Arun District Council
Arun Civic Centre
Maltravers Road
Littlehampton
West Sussex BN17 5LF
Planning & Building Control General Enquiries
Tel: (01903) 737756 Fax: (01903) 730442
Dx: 57406 Littlehampton
Minicom: 01903 732765
e-mail: planning@arun.gov.uk
website: www.arun.gov.uk/planning

Planning (Listed Buildings and Conservation Areas) Act 1990 (as amended)

Application No: LU/135/21/L
Site Address: The Farm 39 East Street Littlehampton BN17 6AU
Description of works: Listed building consent for the subdivision of a single listed building into 2 separate dwellings and essential roof strengthening works.

Thank you for your internet representation made on 24th June 2021 which has been recorded as no objection with the comments as follows:

North Elevation

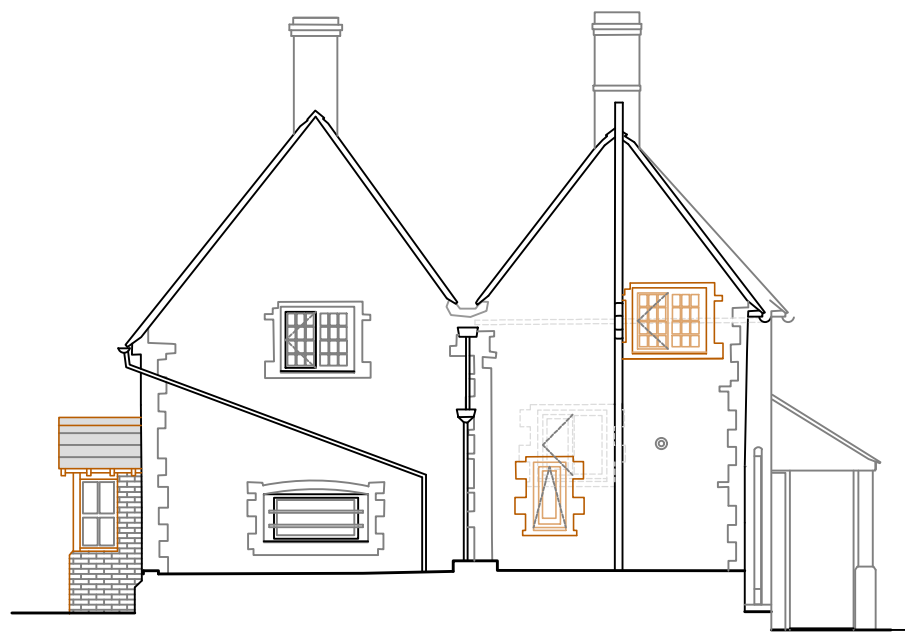
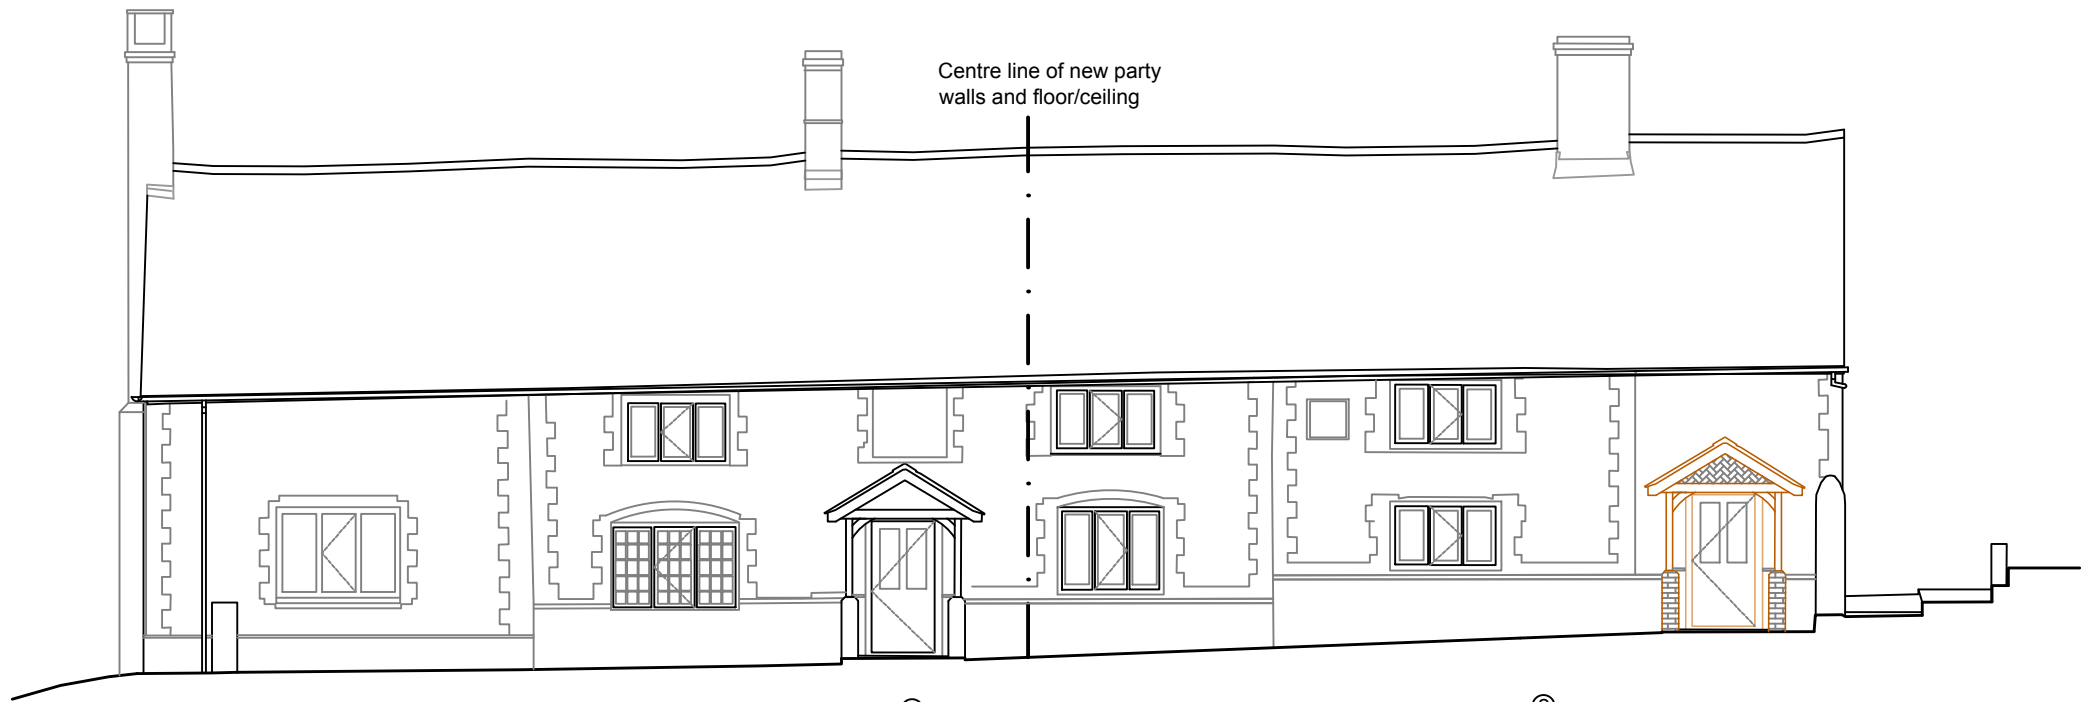
However, precise details of the materials, design, and opening mechanism of the proposed new window on the north elevation of the building should be submitted to the Council. So, too, should details of the materials, finishes and detailing of the proposed rear extension and front porch.
